Level I Site Plan Application
Towle Single Family
CBL: 373-A-016001
Project ID: 2016-01988
Project Address: 1643 Washington Avenue

We received your review comments for the above referenced site plan.

TOWLE RESIDENCE
GARAGE PLAN
WASHINGTON AVENUE
PORTLAND, MAINE

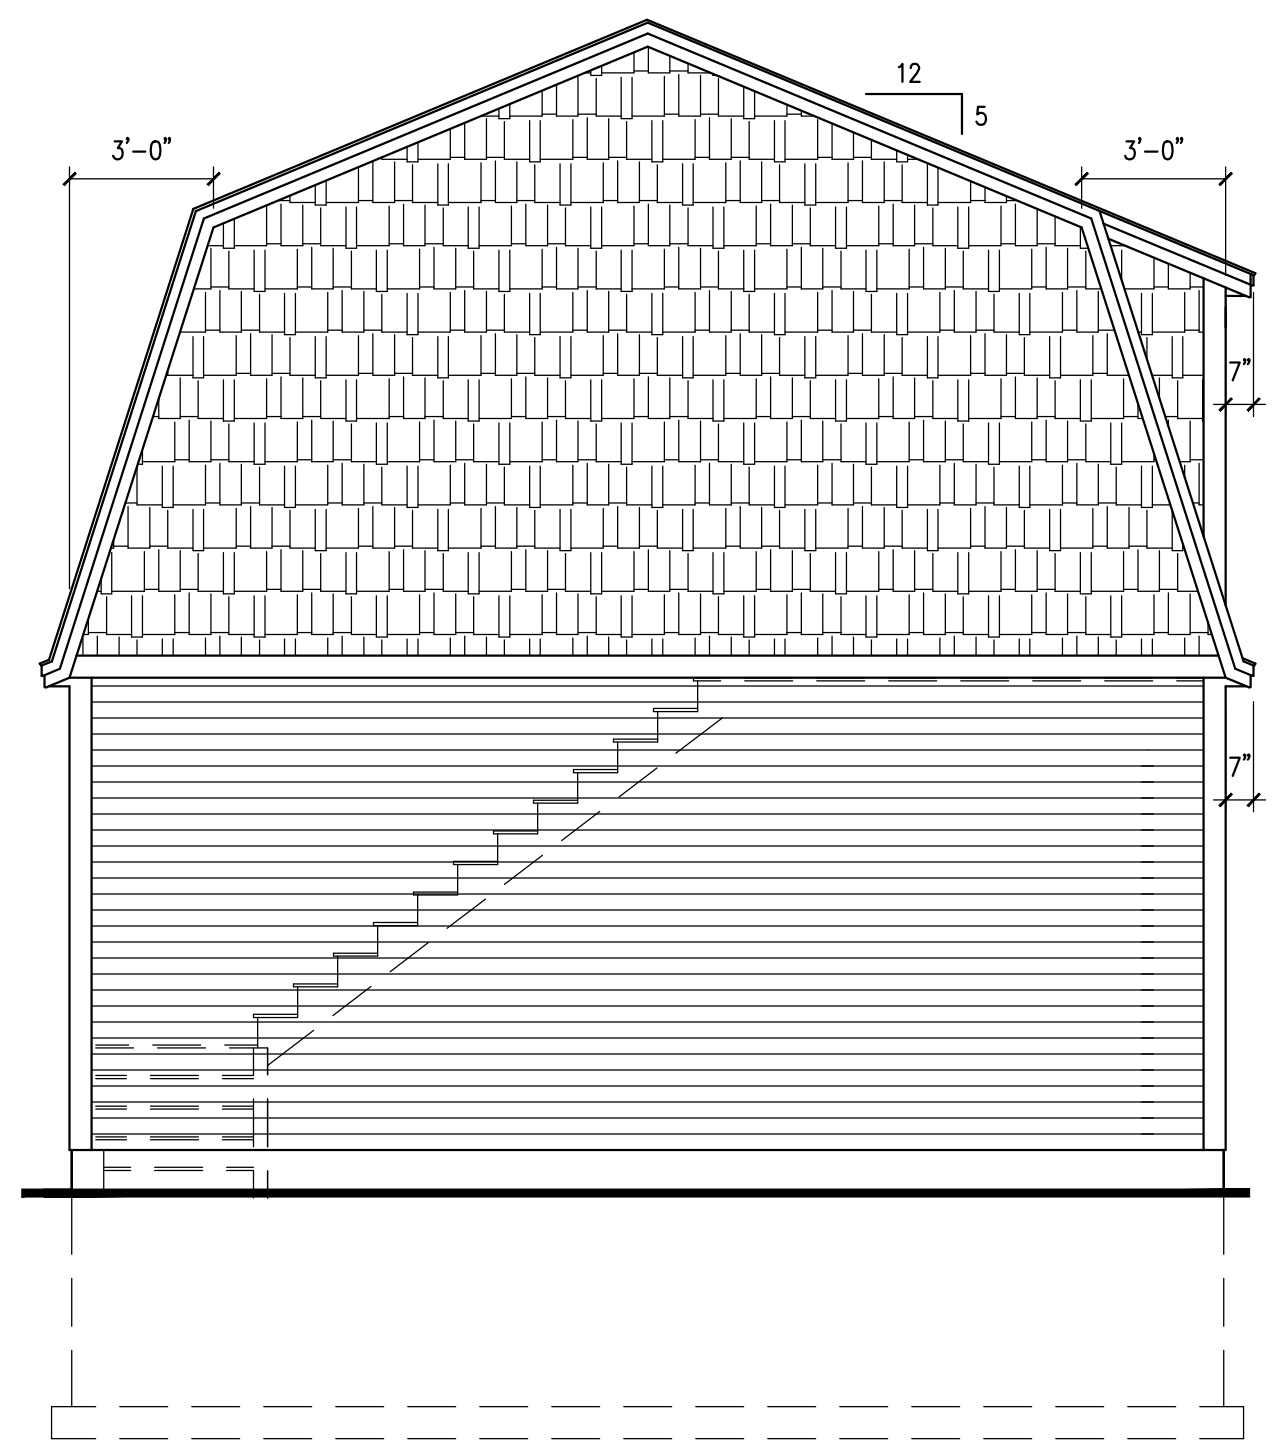
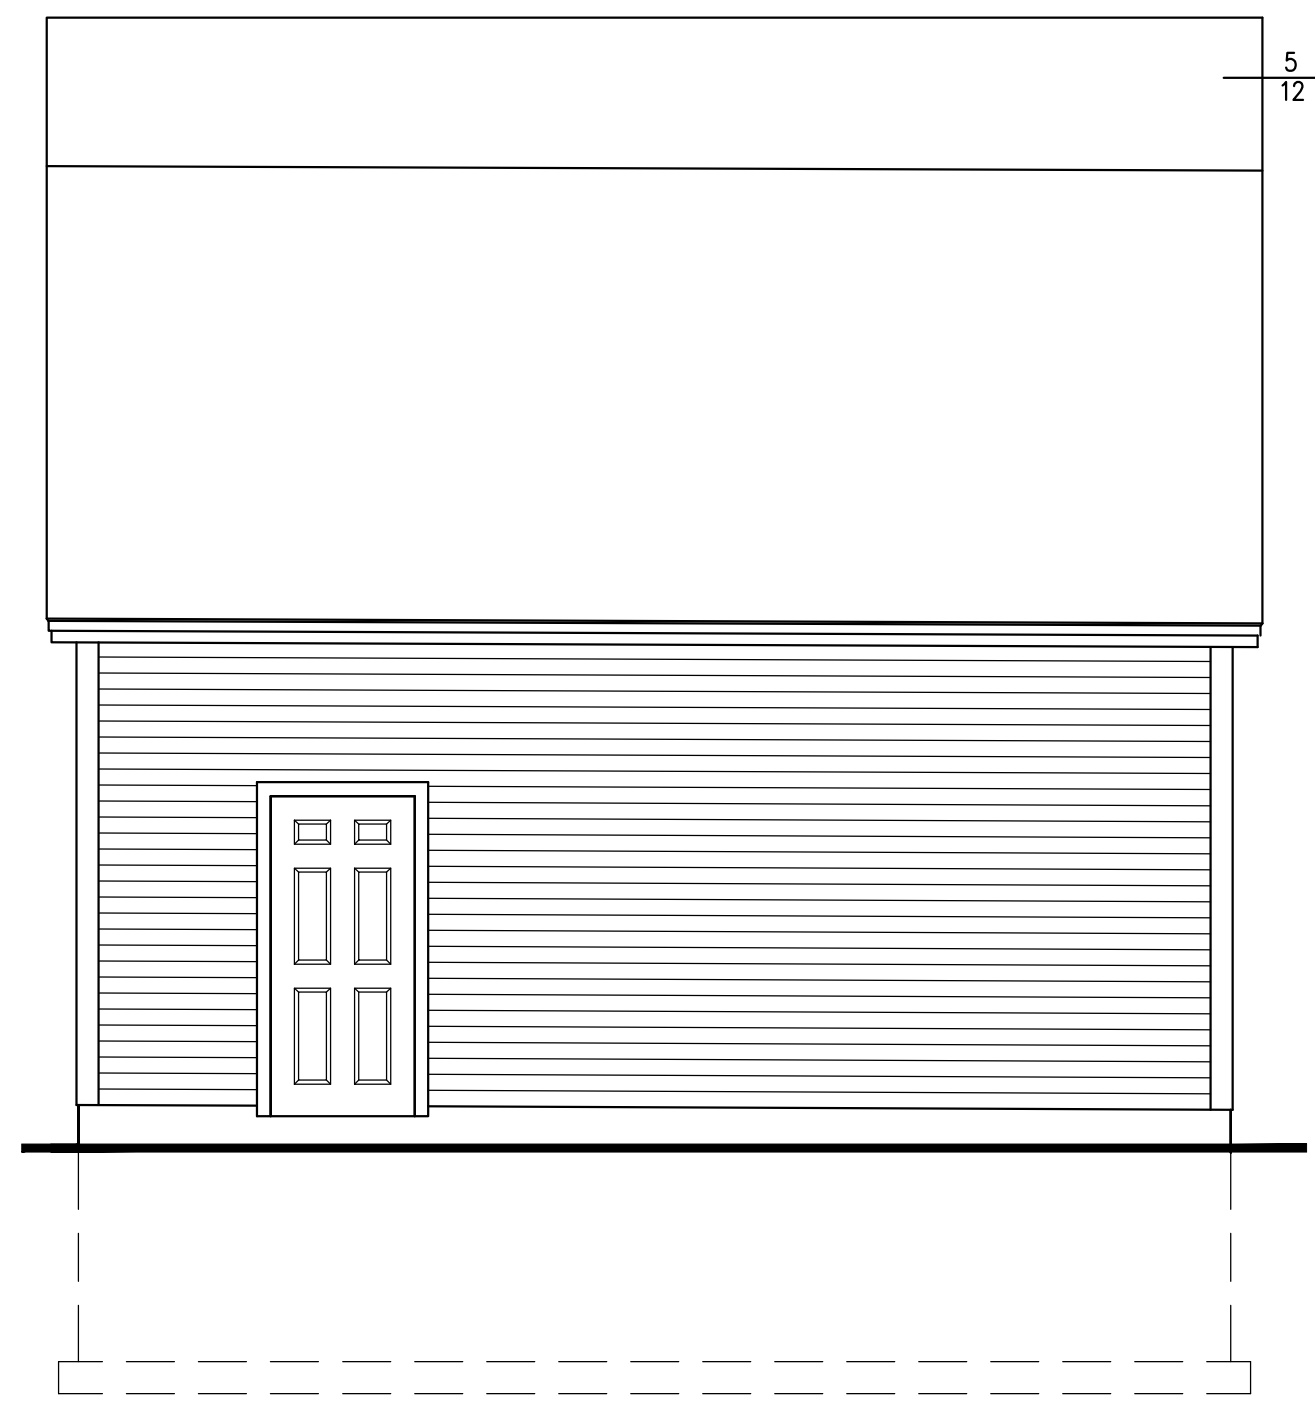
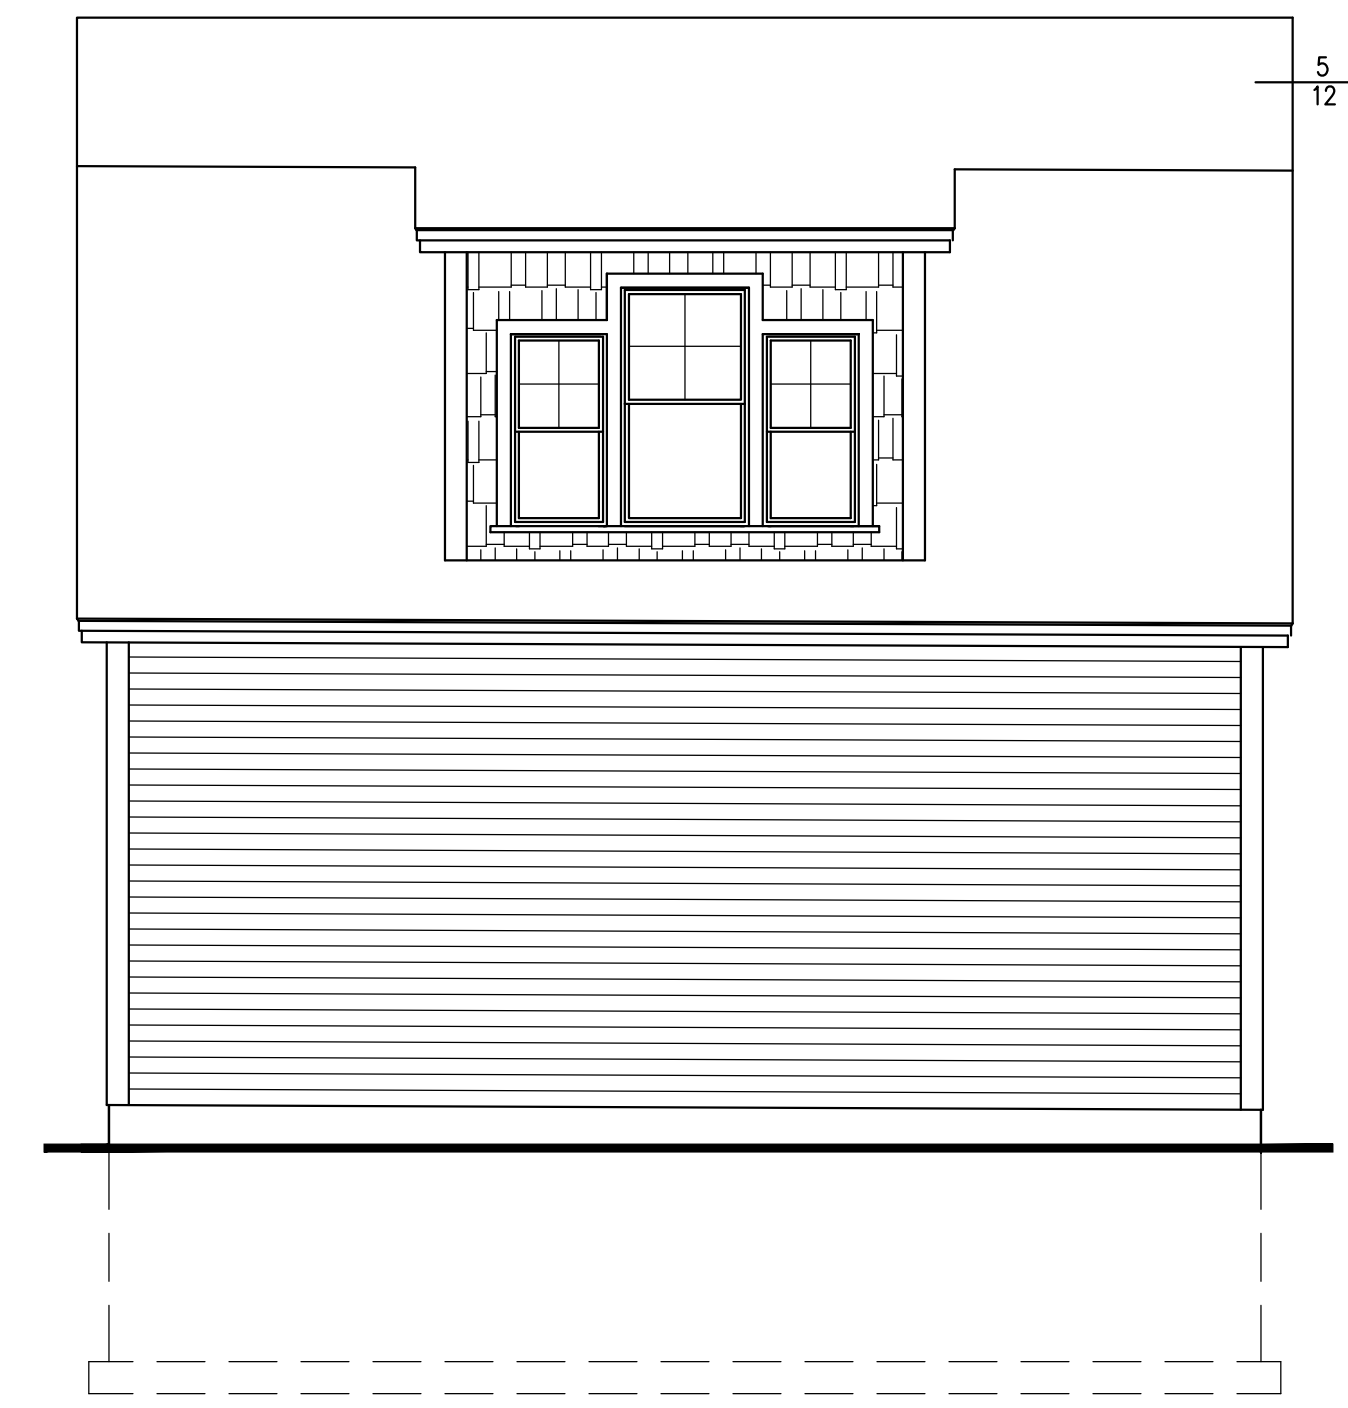
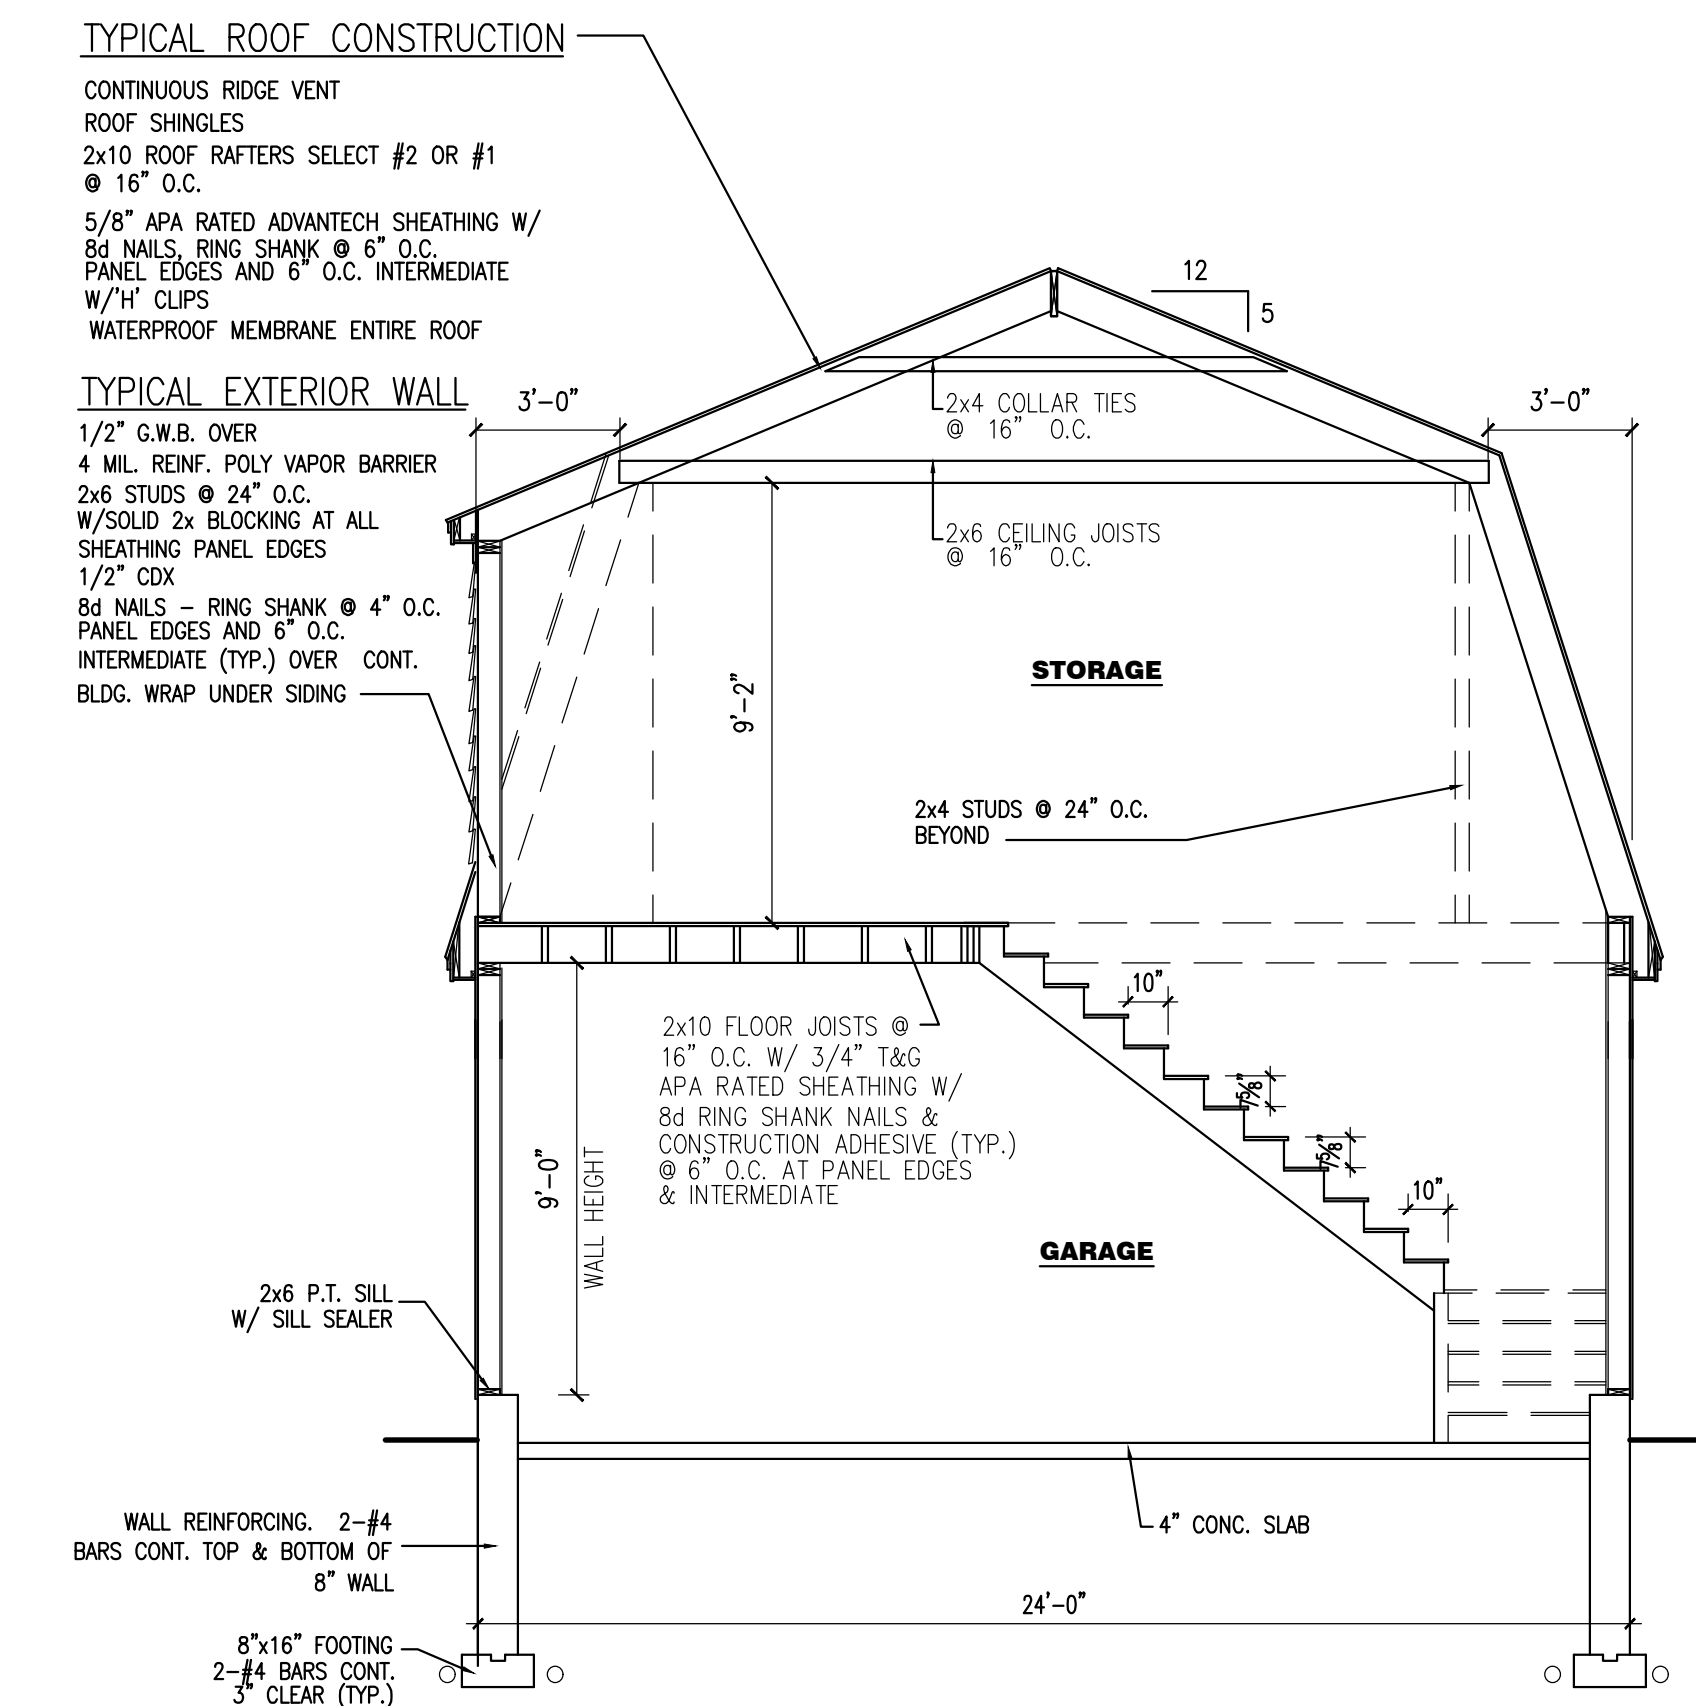
- *Zoning Specialist Chris Stacey has reviewed the project for zoning compliance and identified one issue regarding the proposed detached garage. In this zone, a detached structure is limited to 18 feet in height. The height of a gambrel structure is defined as "the vertical measurement from grade to a level two-thirds the distance from the level of the eaves to the highest point of the gambrel roof." Based on the submitted plans, it appears that the height of the garage is about 19.5', which would exceed the height limitation. The plans should be revised so that the garage meets this limitation. If you have questions about this, please contact Chris directly at 207-874-8695 or cstacey@portlandmaine.gov." The updated build plans have been attached.*

GRADING AND UTILITY PLAN  
OF:  
**PROPOSED LOT DIVISION**  
1637 WASHINGTON AVE  
PORTLAND, MAINE  
FOR:  
**STAN AND SANDY TOWLE**  
15 BRYANT STREET  
SOUTH PORTLAND, MAINE 04106

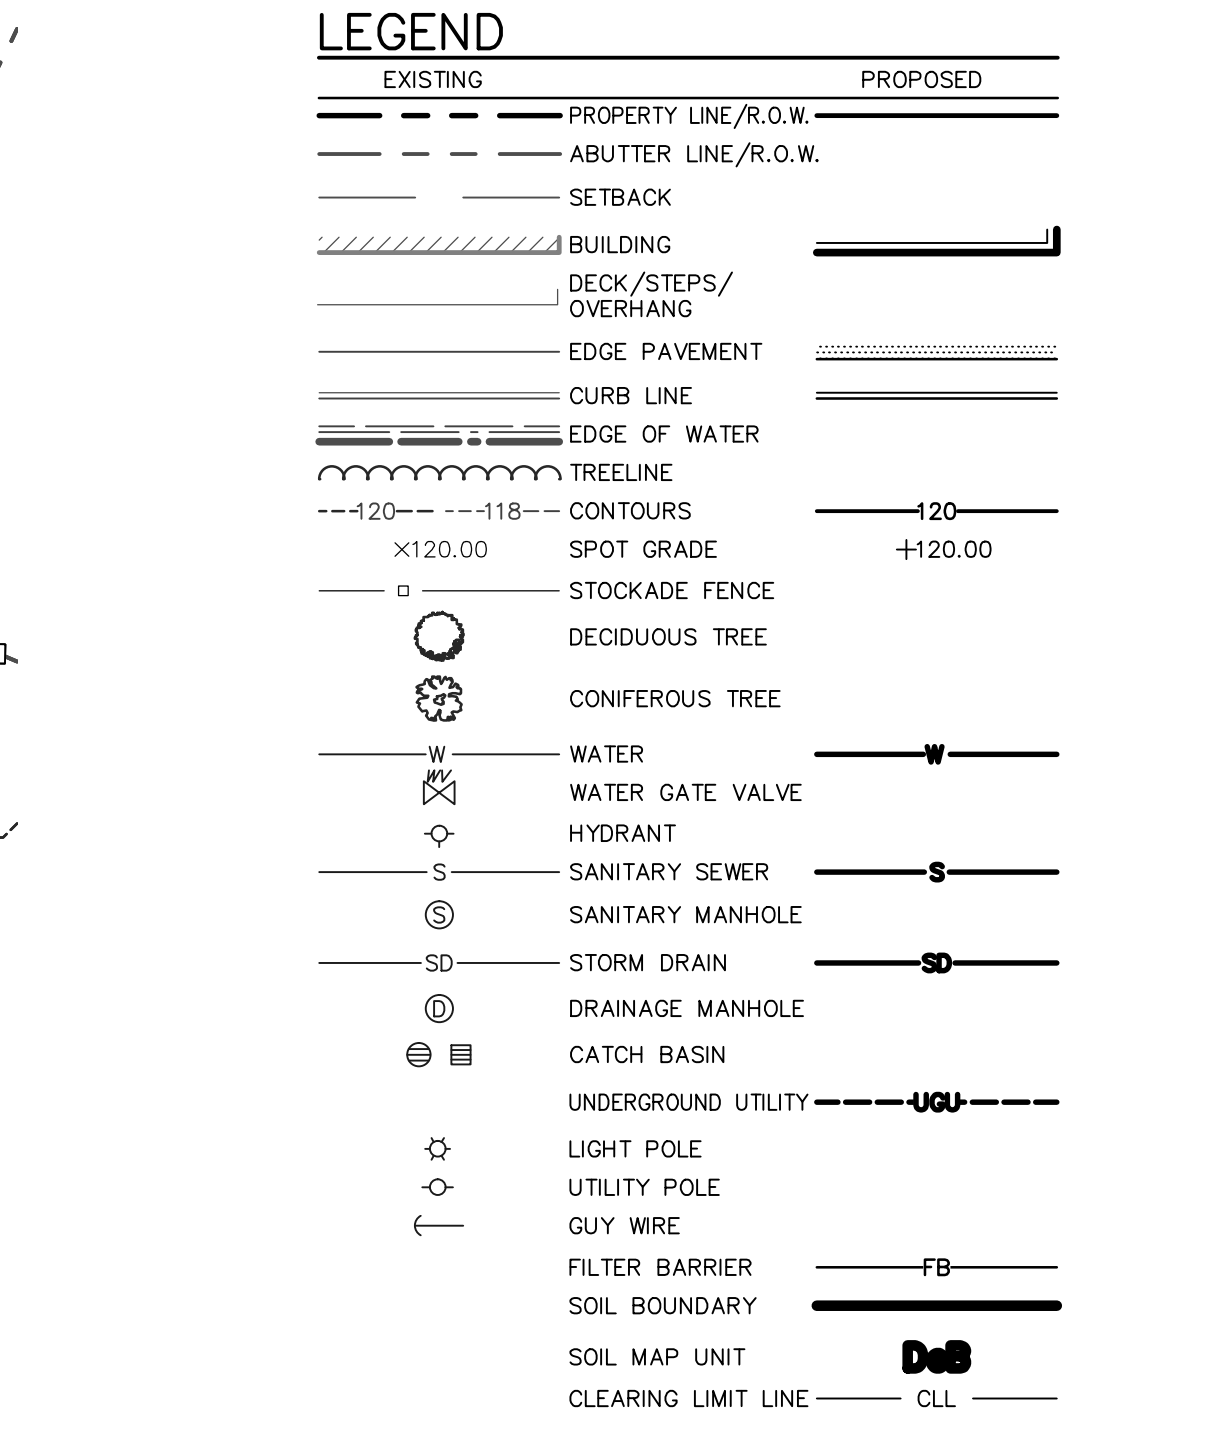
1. *Please submit a revised site plan that includes the following information:*
 - *Please add the ground floor areas and the finished floor elevation to the site plan. The ground floor area has been added to the site plan.*
 - *Please add the NRCS soil type to the site plan. The soils types have been added to the Grading and Utility plan.*

- *Please add to the site plan, the location, area, and limits of the proposed site disturbance. The construction clearing limit line has been added the Grading Utility Plan.*
